# ENG-SF22025-R1-PDR.pdf Markup Summary

Cursory comments. See comments on FDR and comment memo

# EAGLE RISING HYDROLOGY MAP (OFF-SITE)

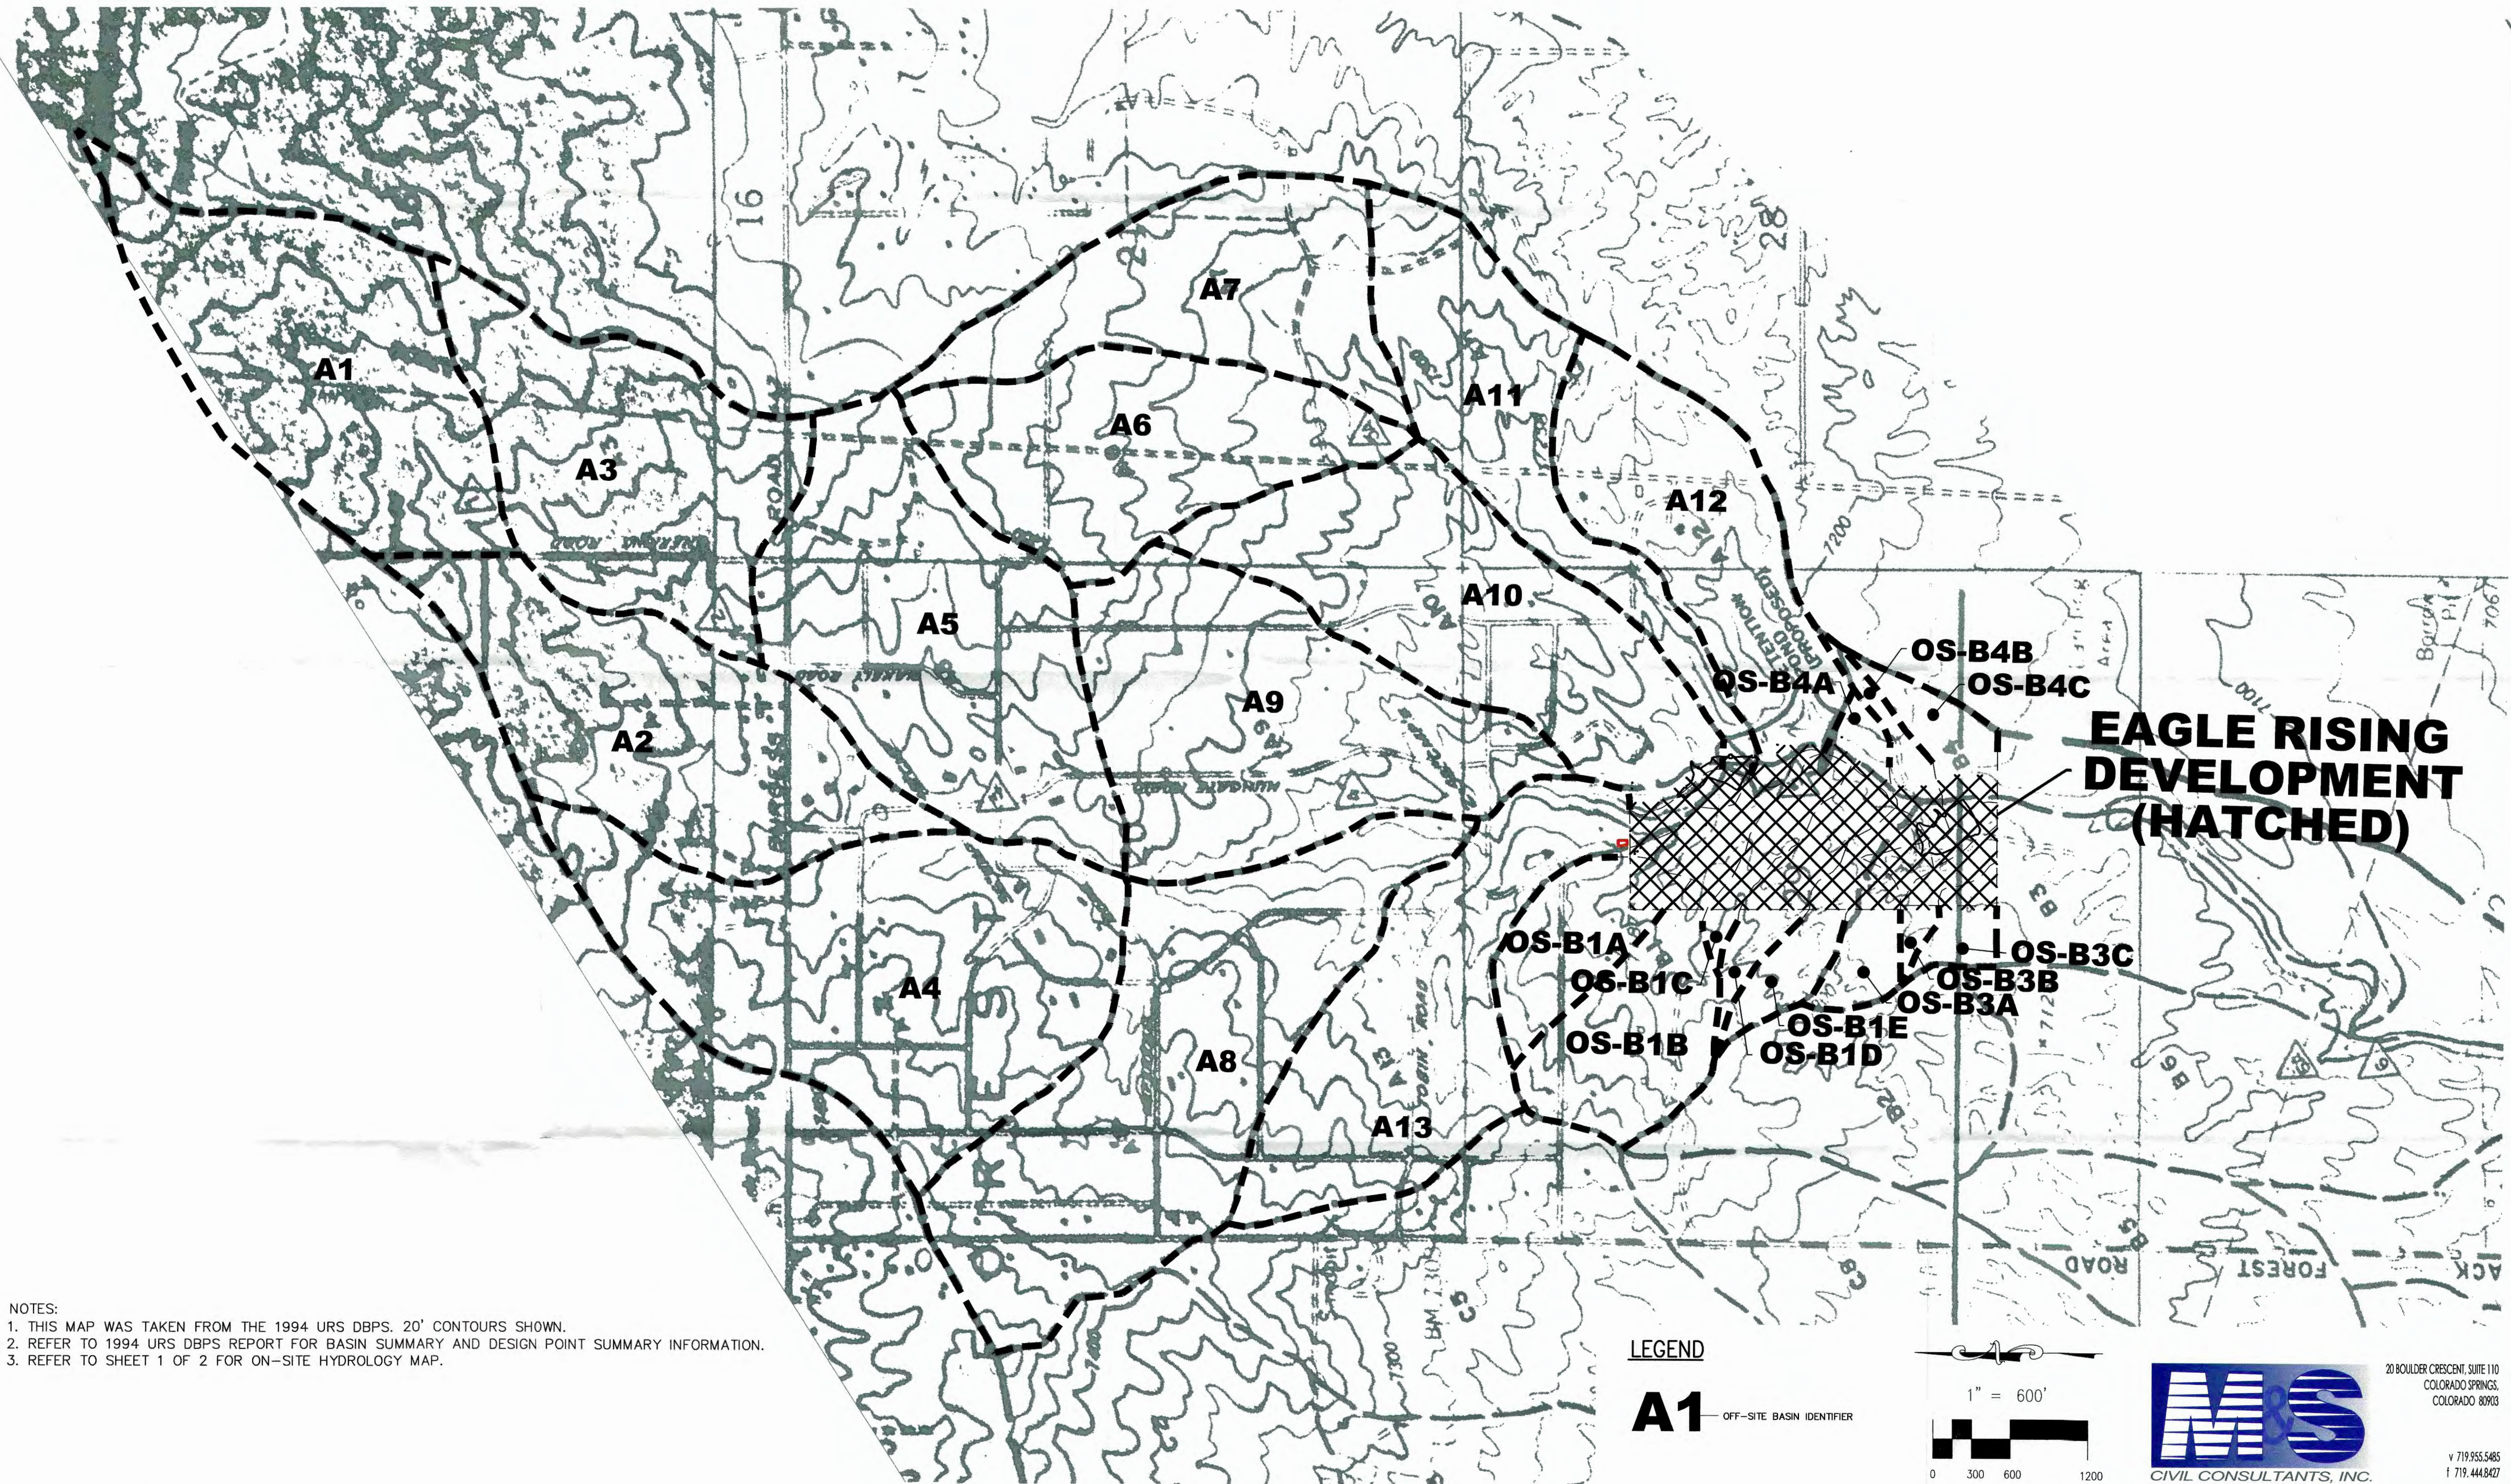
This is not an approved plan

# EAGLE RISING HYDROLOGY MAP EXISTING (ON-SITE)

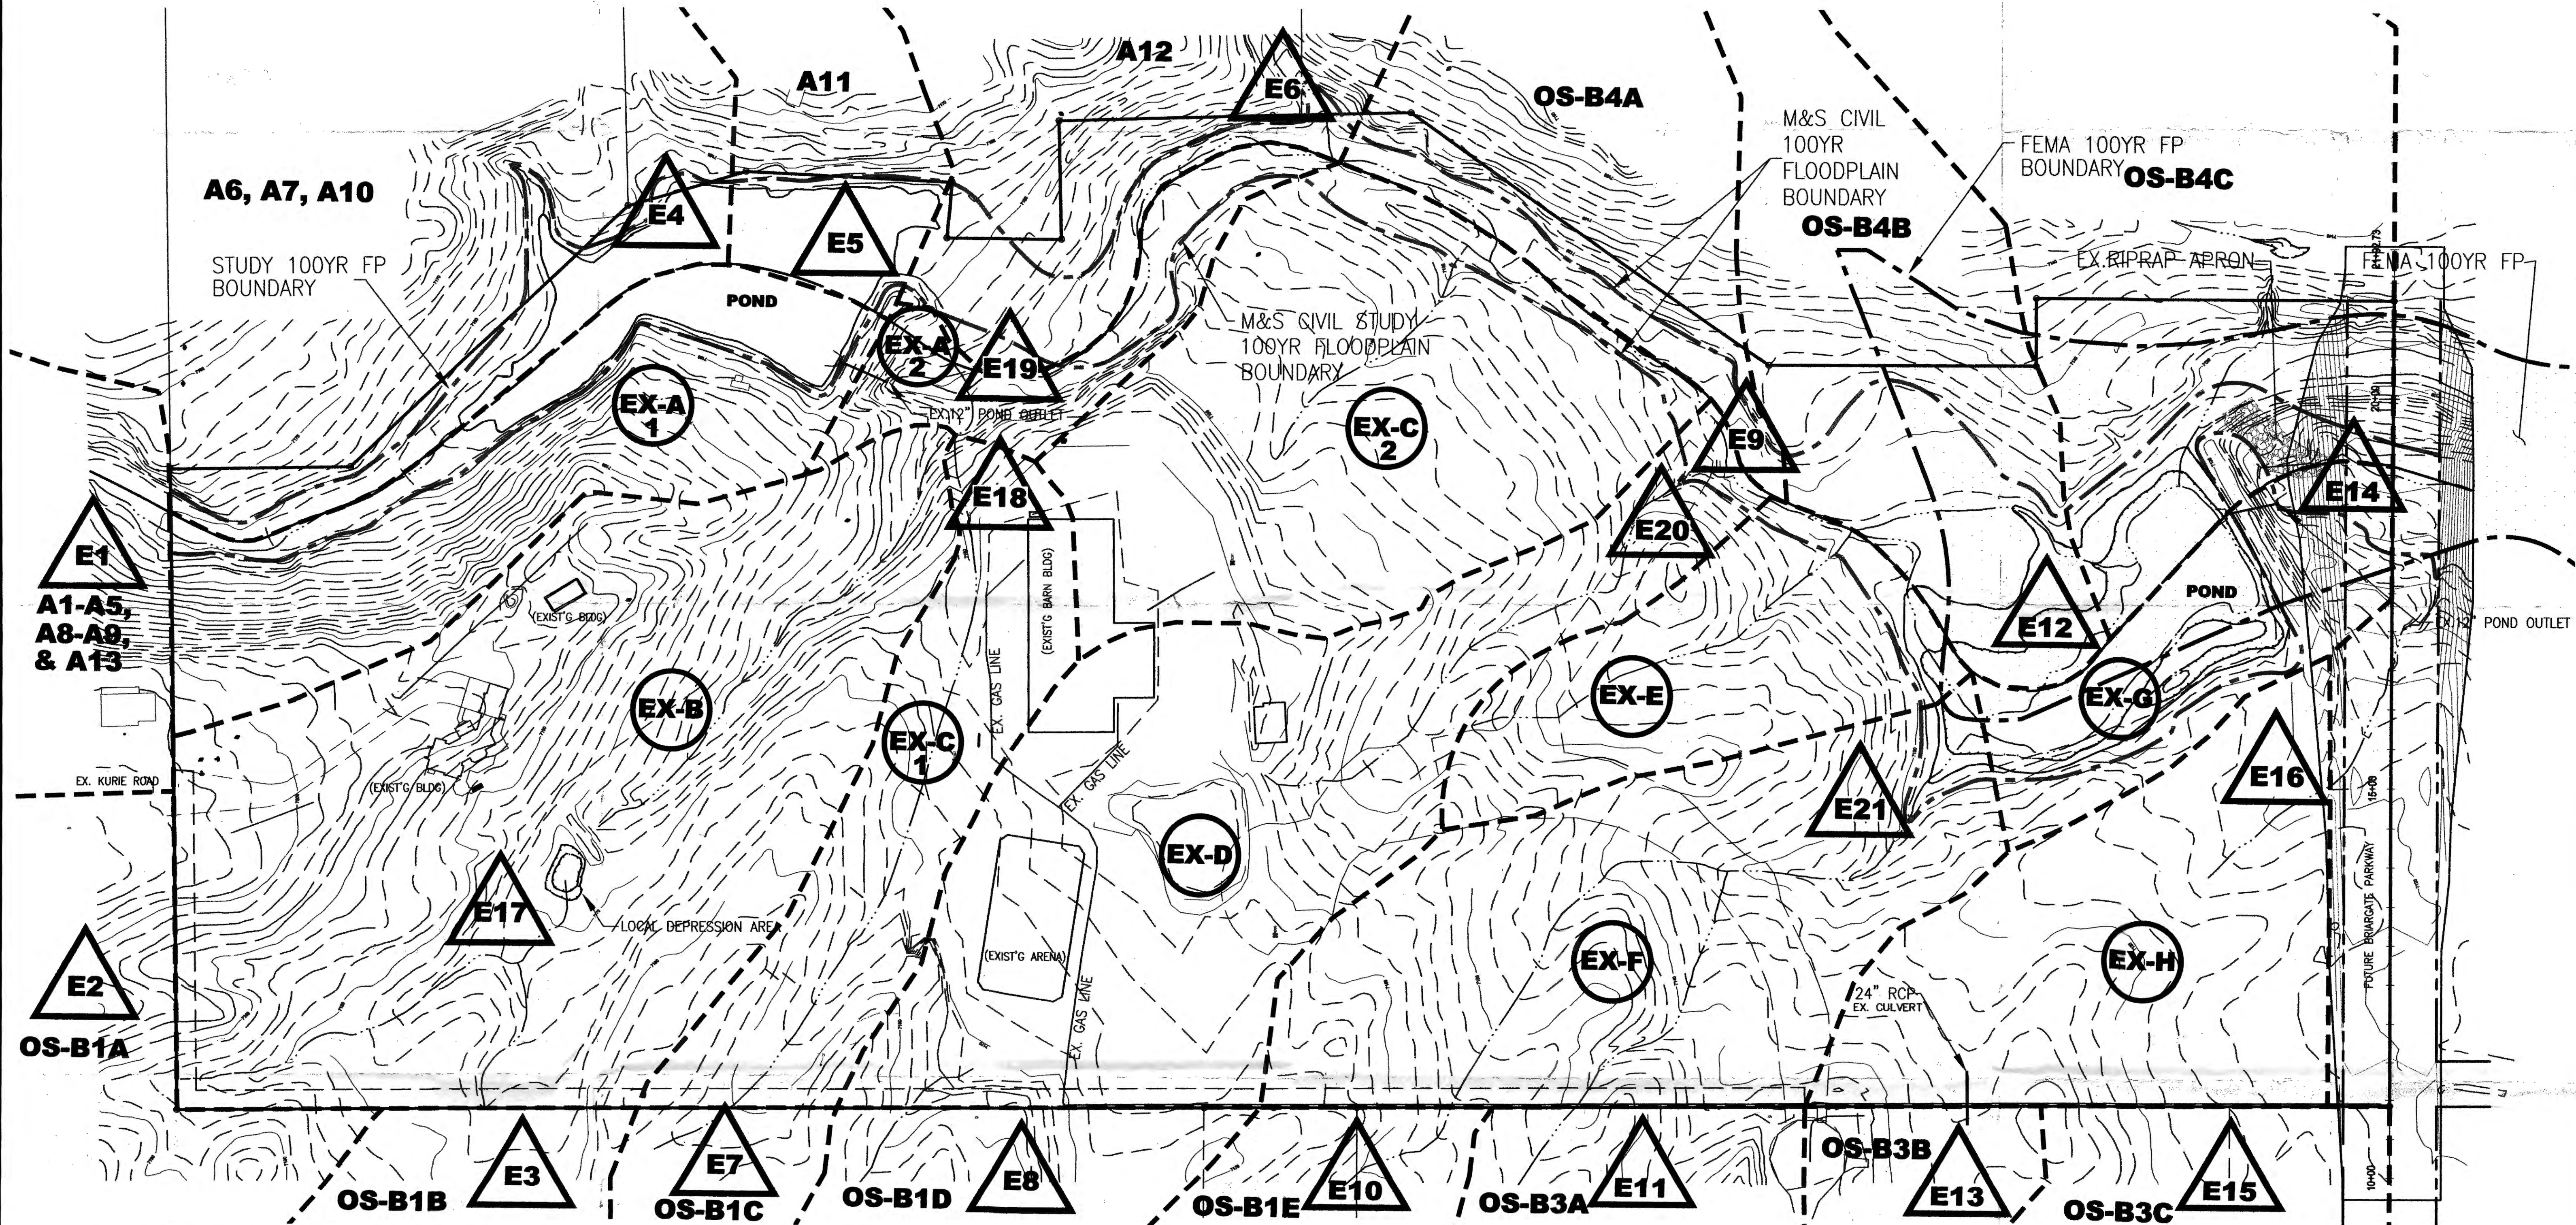
Can the septic system be on a different lot?

Show and label buildings to be removed

Needs to be constructed by developer if serving more than one lot

Adjust the basin lines to account for road construction
